Consultation Response from: KC Environmental Health (Pollution & Noise Control)		
2025/90548 78 John William Street, Huddersfield, HD1 1EH		
Change of use and alterations to convert offices to 14 apartments (use class C3) (Listed Building within a Conservation Area)		
Responding Date: 1 st July 2025	Responding Officer: SR	Responding Ref: WK202518375
<u>Comments</u> We have reviewed the application in relation to the elements within the remit of Environmental Health and make the following comments and recommendations. The building is located within the town centre of Huddersfield on busy roadways; plans show bedrooms and living rooms at below ground floor with windows at street level. <u>Air Quality</u> An undated, unreferenced Air Quality Statement by C49 Architecture Ltd has been submitted in support of the application. The proposed development is located in Huddersfield Town Centre which has been declared an Air Quality Management Area (AQMA 9) for exceedances of the annual mean nitrogen dioxide (NO₂) objective. An air quality assessment therefore is required to determine the impact of the development on local air quality during the construction and operational phases, and the li

www.C49-Architecture.co.uk Info@C49Architecture.co.uk Tel: 01535 281432	CLIENT DETAILS JOHN WILLIAM STREET HUDDERSFIELD		DRAWING No JWS PL 001	REVISION A
	DRAWING INFO Existing Plans	SCALE 1:100	DATE 25/06/23	DRAWN BY JH

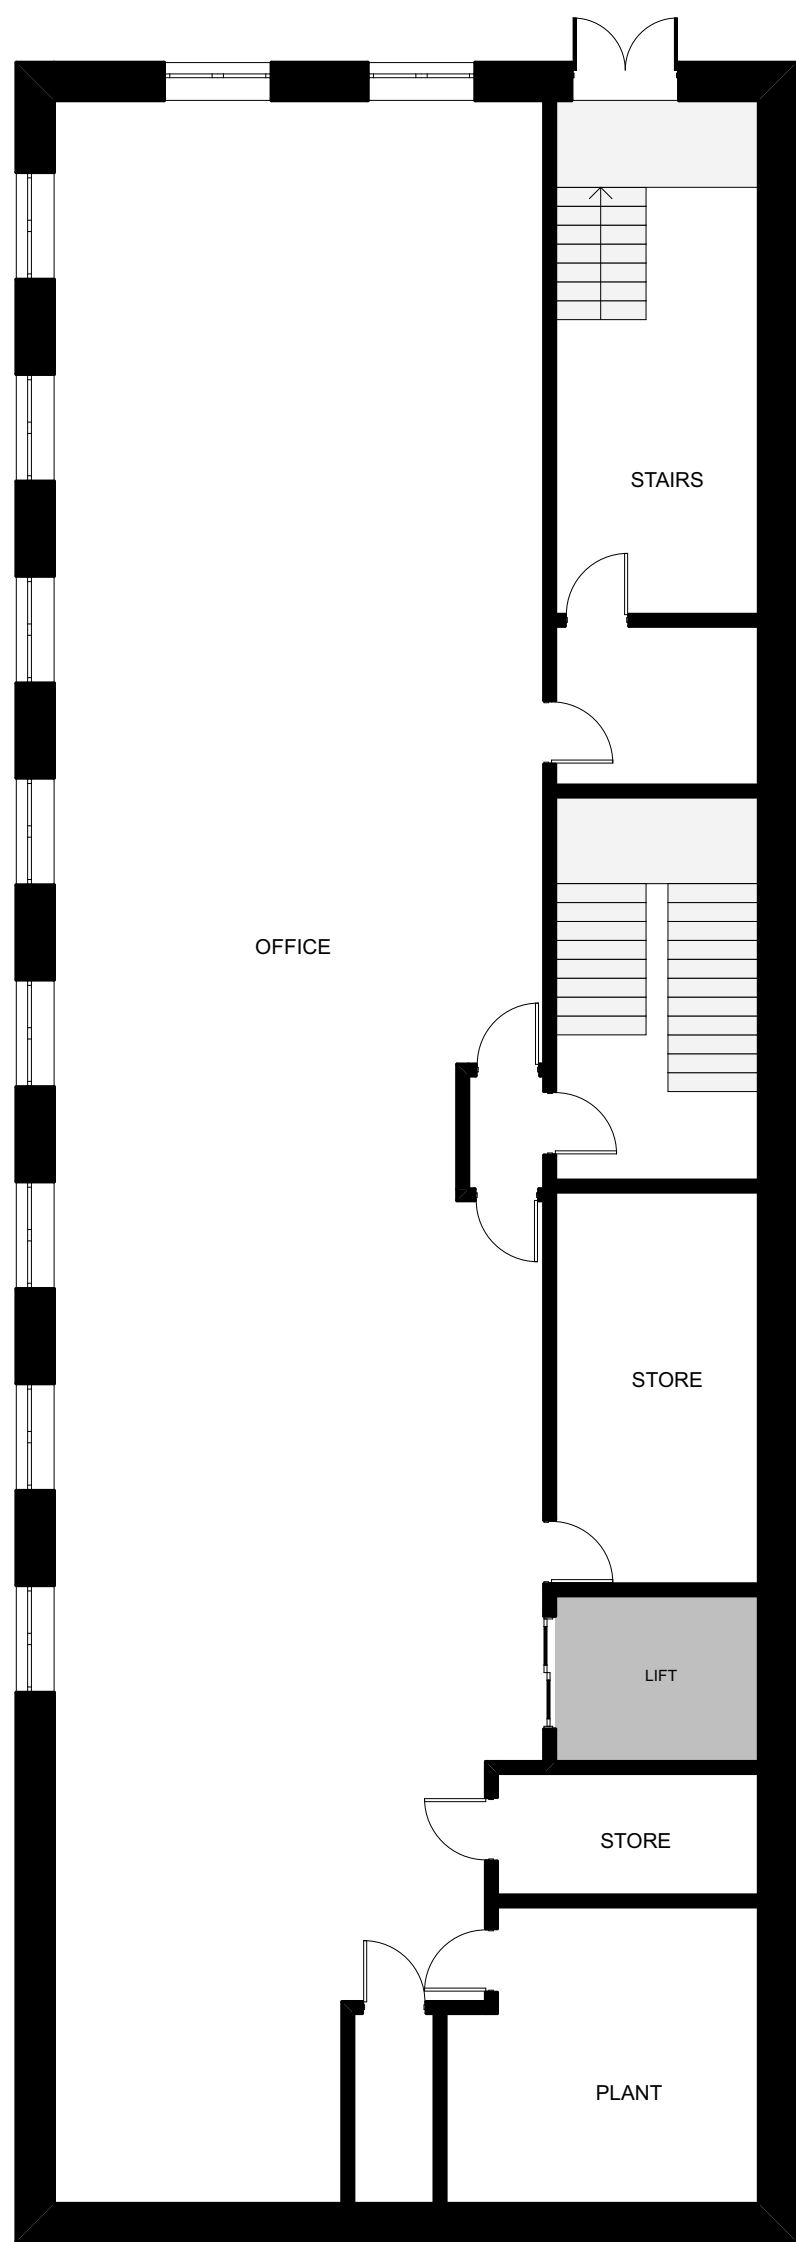
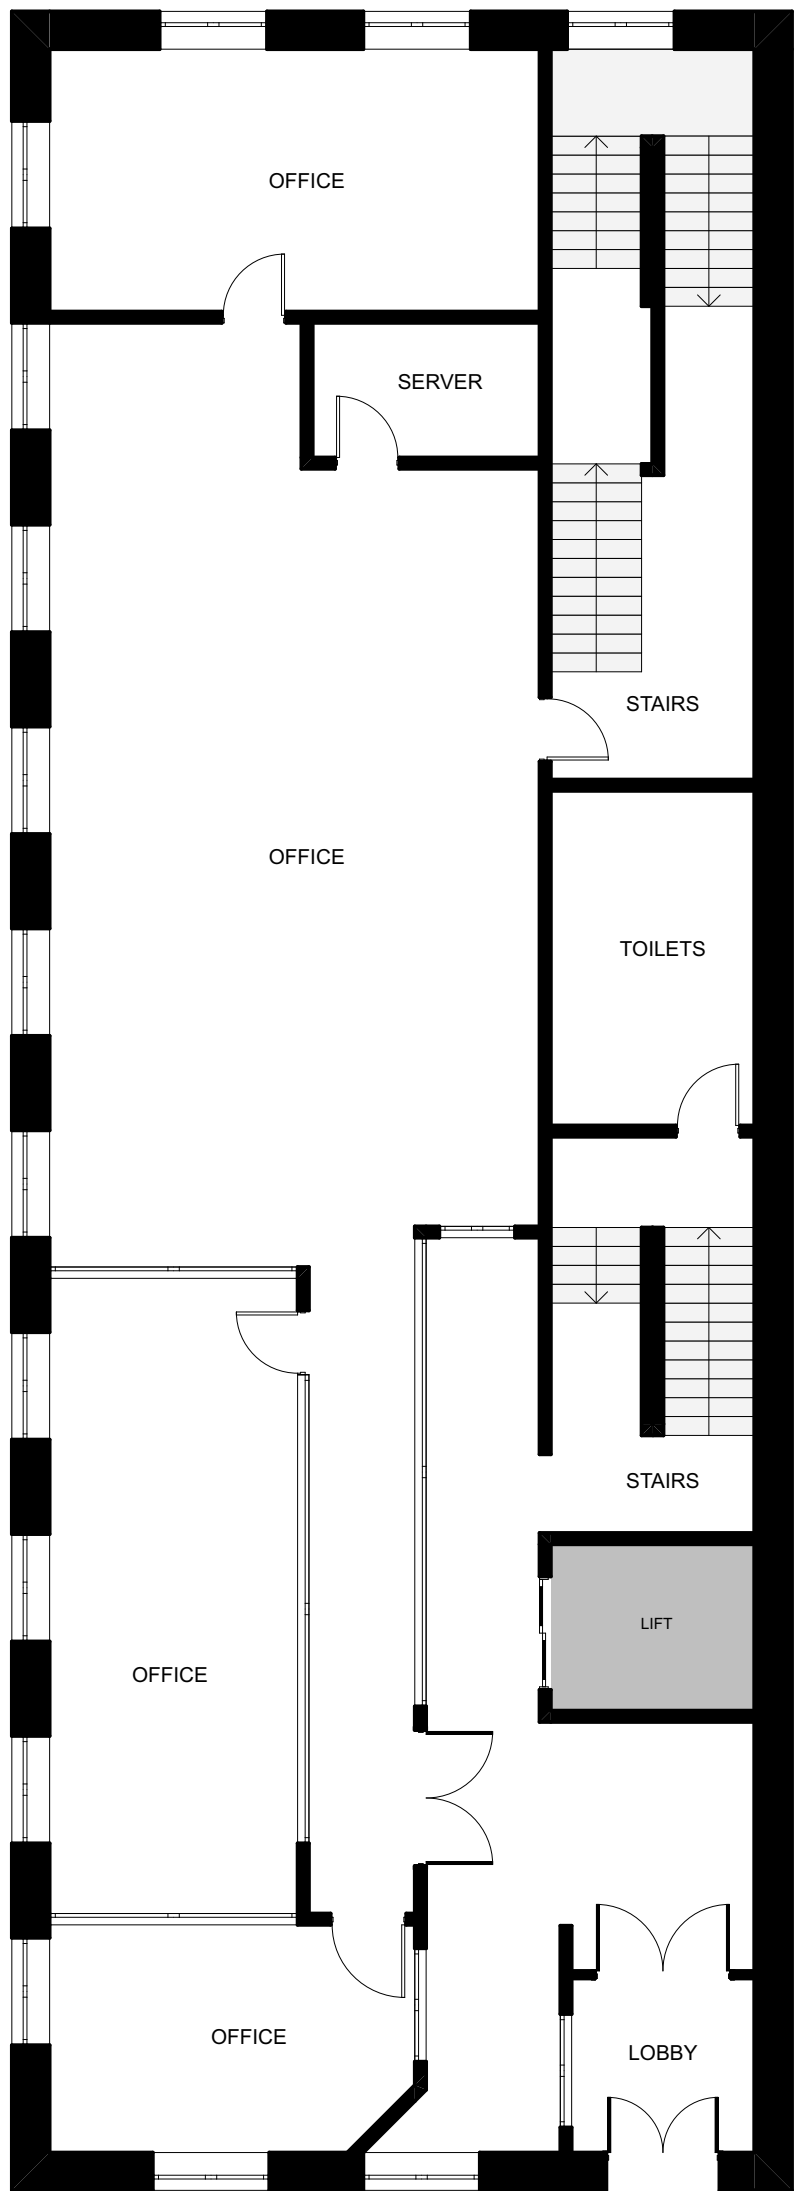
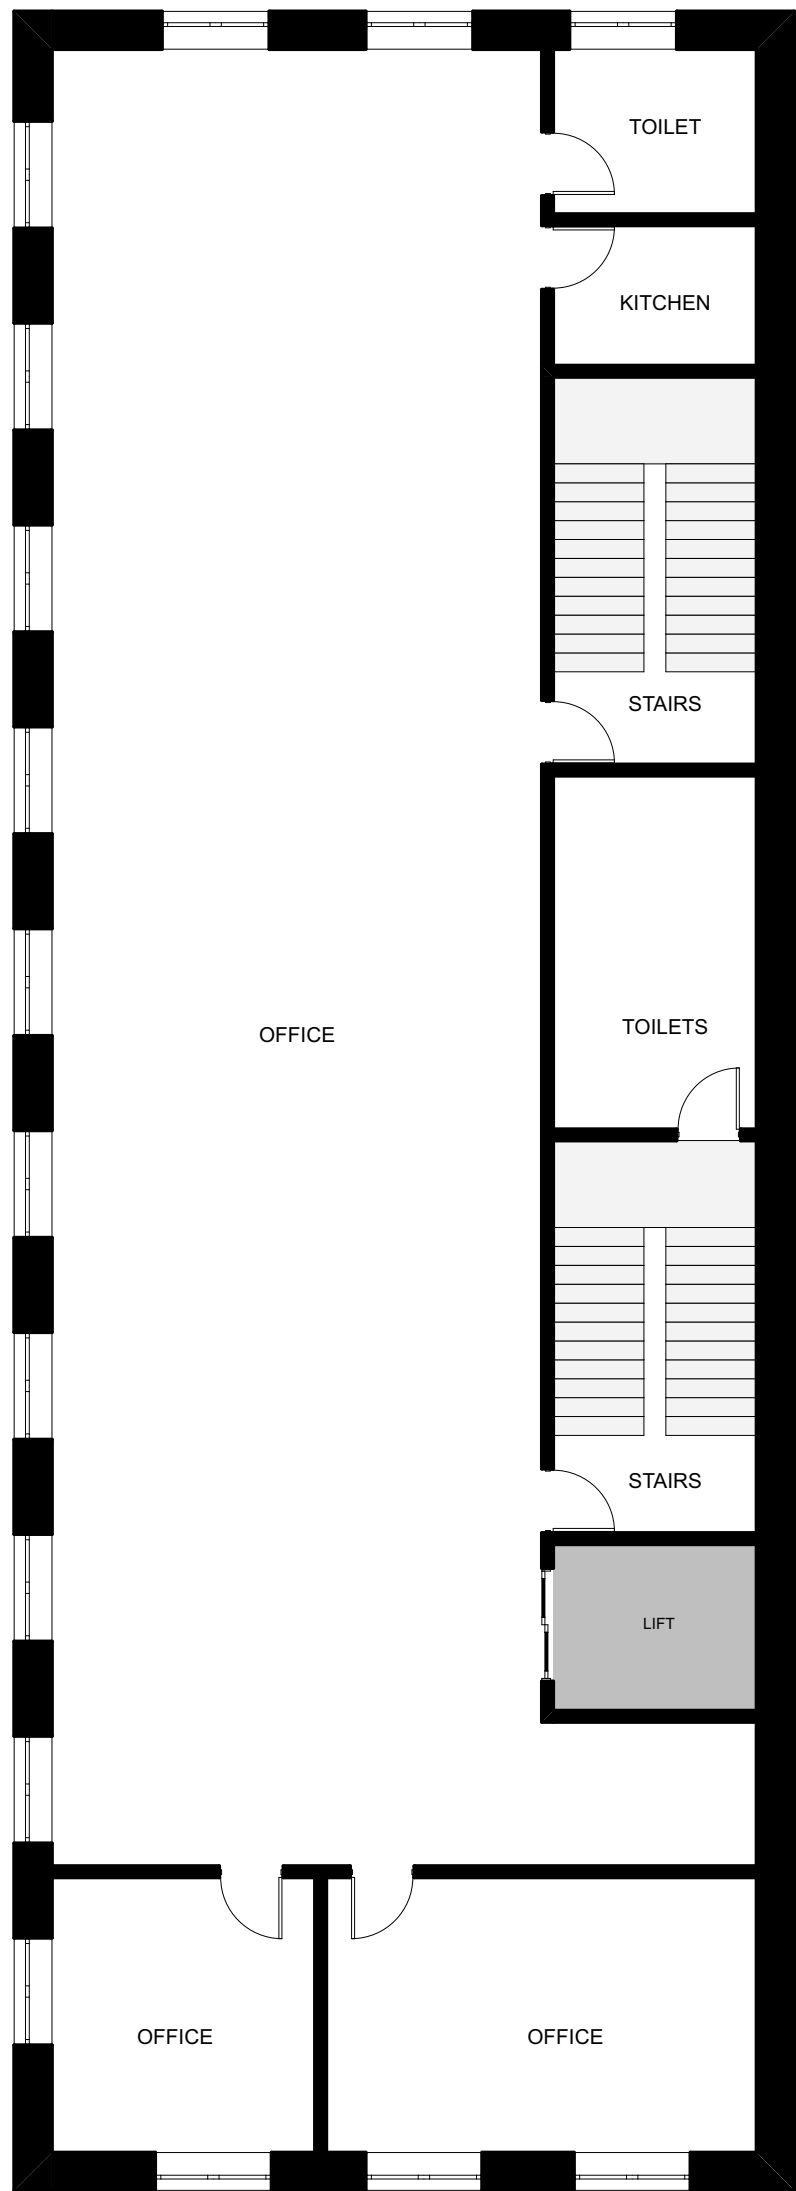
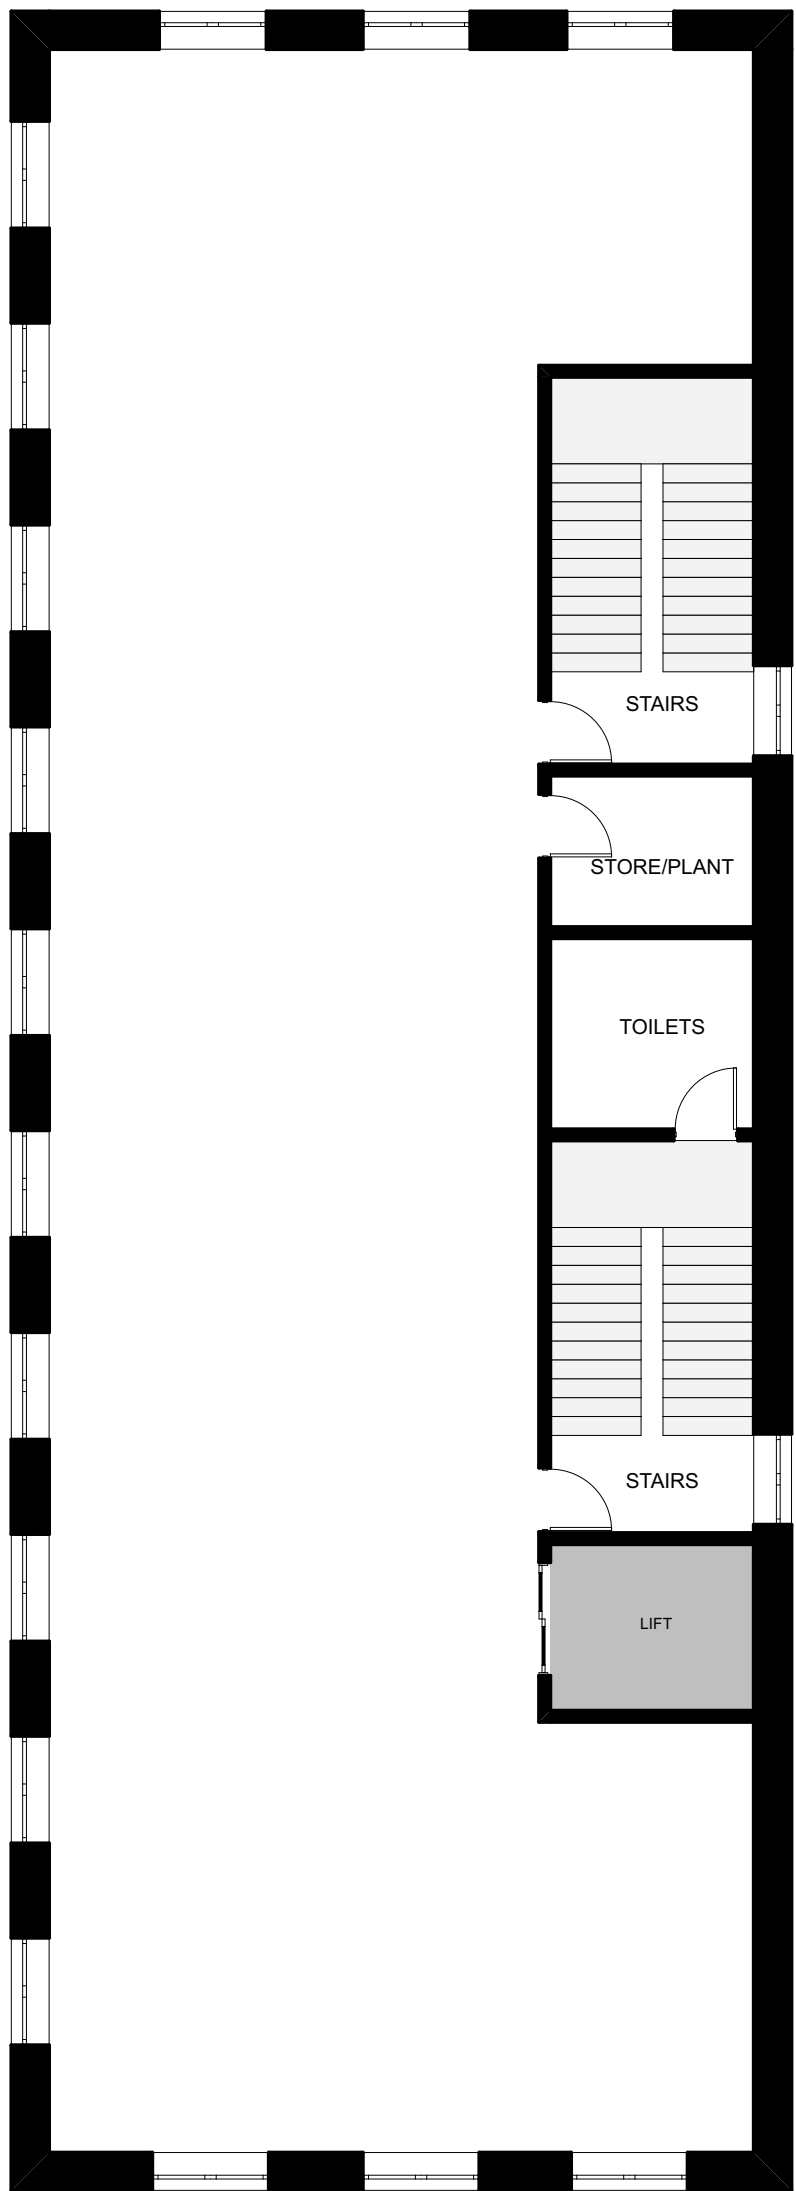
Before the application can be determined, details of an assessment of all significant noise sources likely to affect the proposed development including road/rail traffic and commercial premises by a suitably competent person (see note) must be submitted in writing to the Local Planning Authority. The report shall:

- a) Determine the existing noise climate
- b) Predict the noise climate in the living rooms (daytime), bedrooms (night-time) and other habitable rooms of the development
- c) Detail the proposed attenuation/design necessary to protect the amenity of the occupants of the new residences. If the noise attenuation measures include windows being kept closed, then details of alternative ventilation over background ventilation will be required. If levels predicted in the report are unacceptable, it may be necessary to refuse the application. Otherwise, it may be necessary to specify attenuation measures as conditions of consent.
